From: Julie Grieves on behalf of Planning.Responses
Sent: 26 October 2017 10:02
To: Planning Scanning
Subject: FW: Planning Consultation on LU/253/17/DOC

APPLICATION **LU/253/17/DOC**

Site Address: Land adjacent to Shell Garage Worthing Road Littlehampton

Description of Works: Application for approval of matters reserved by condition imposed under LU/20/17/PL relating to conditions 3 for schedule of materials & finishes, 4 for surface water drainage & 5 for scheme to deal with risks associated with site contamination.

Engineering Layout

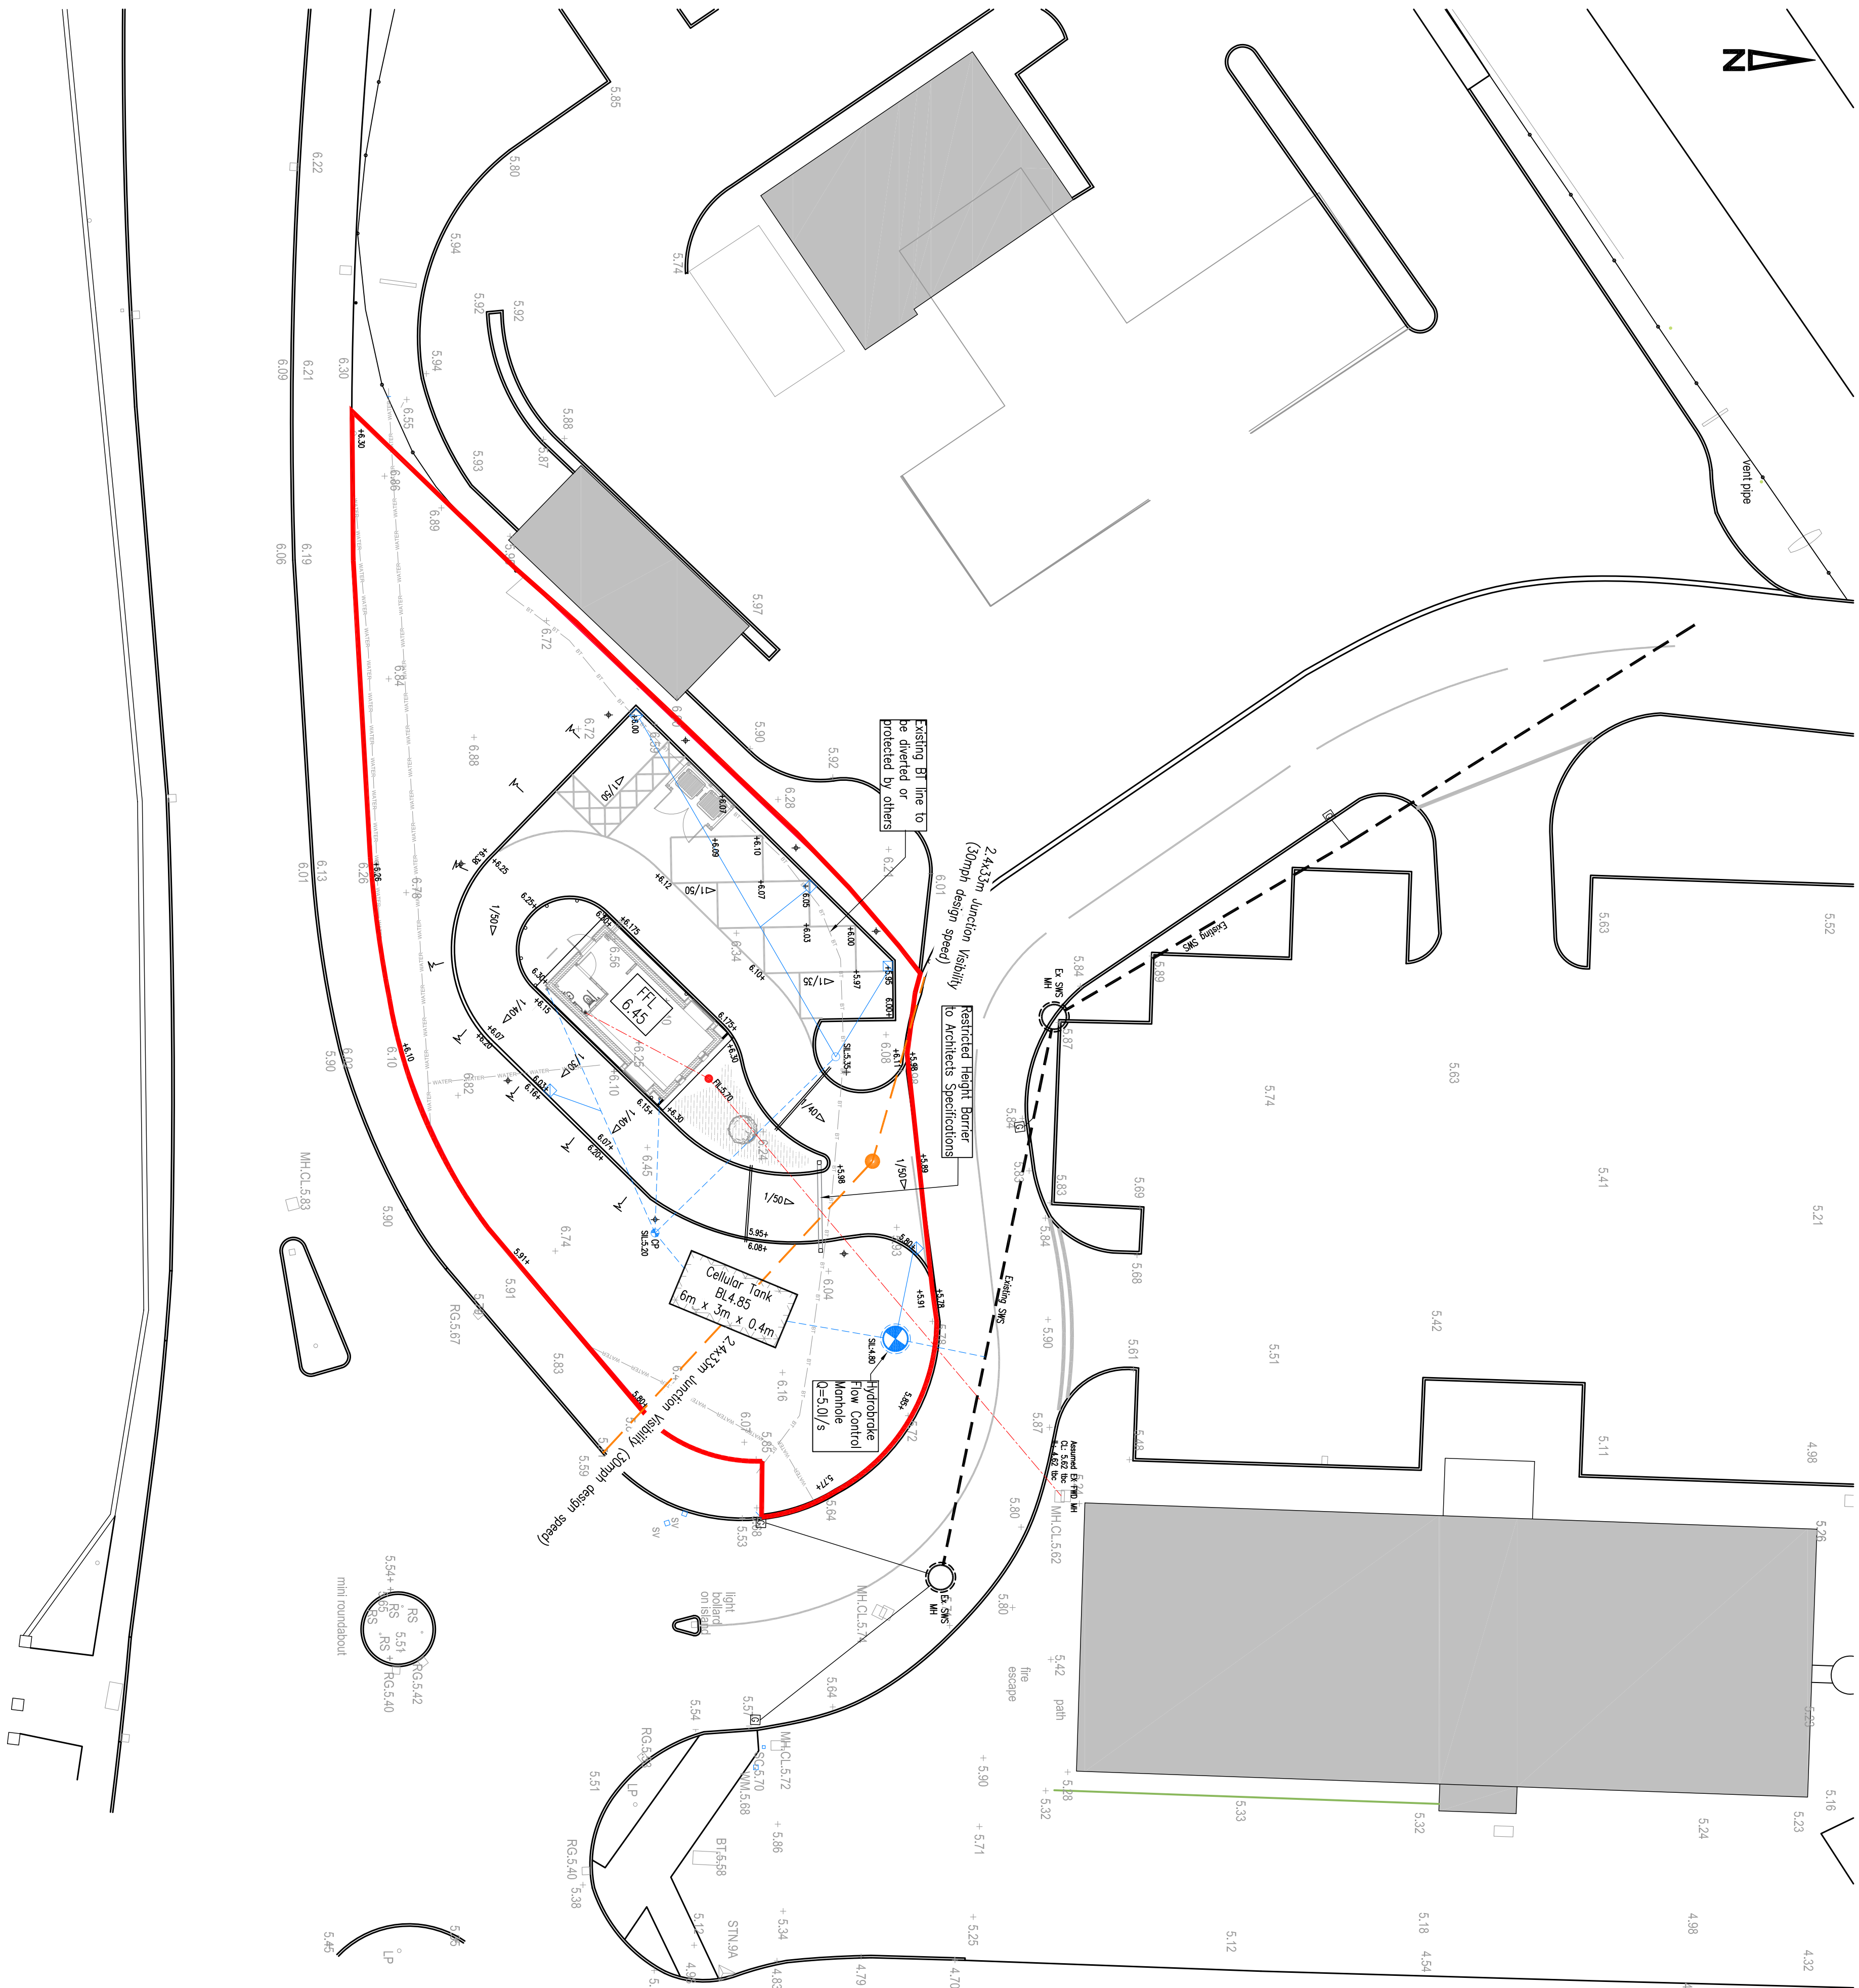
It is noted that the applicant intends to discharge surface water to the adjacent existing surface water drainage system at a restricted rate.

However, they appear not to have fully investigated infiltration options. This needs to comprise of satisfactory winter groundwater monitoring and percolation testing at agreed depths/locations. Soakage must be fully considered as per Approved Document H and national/local guidance, before other options are contemplated.

If soakage ultimately proves not to be feasible, then more information will be required on the adjacent existing drainage system. This can be discussed at the time.

Therefore, at this time I am unable to recommend discharge of the condition.
